WILPSHIRE PARISH COUNCIL

26 July 2012

GT 3/2012/0555 proposed rear extension at 22 Vicarage Lane Wilpshire

Proposed South West Elevation.

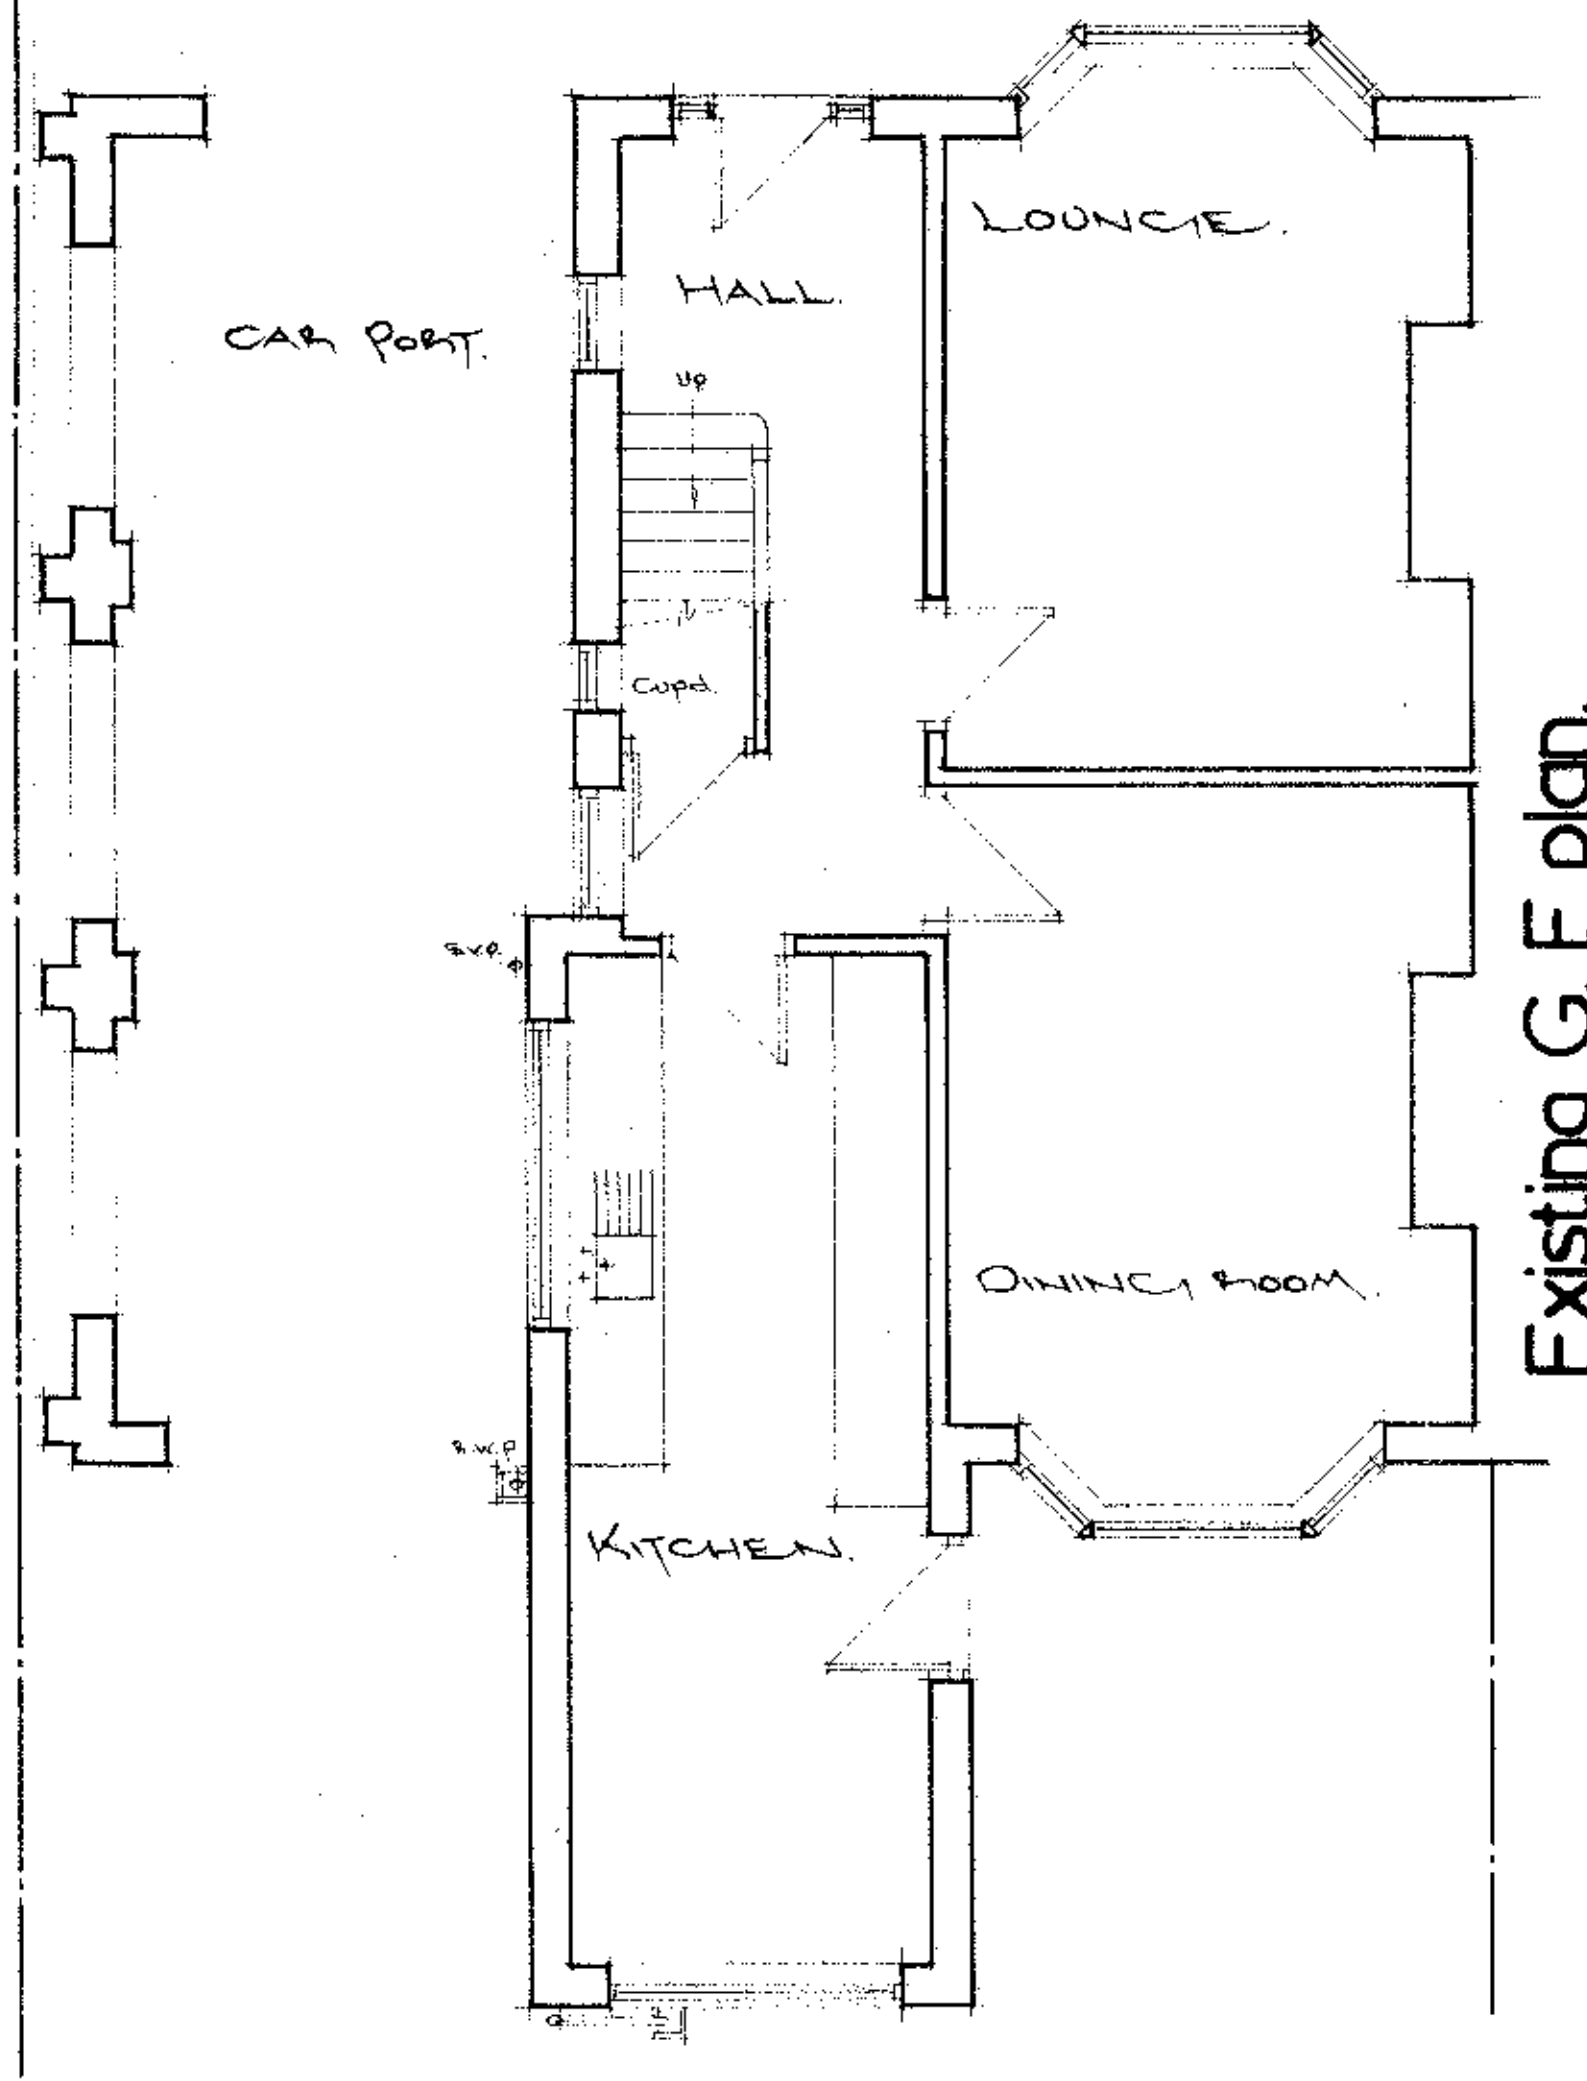
The parish council would comment that it believes that the proposed extension could take light away from the adjoining property.
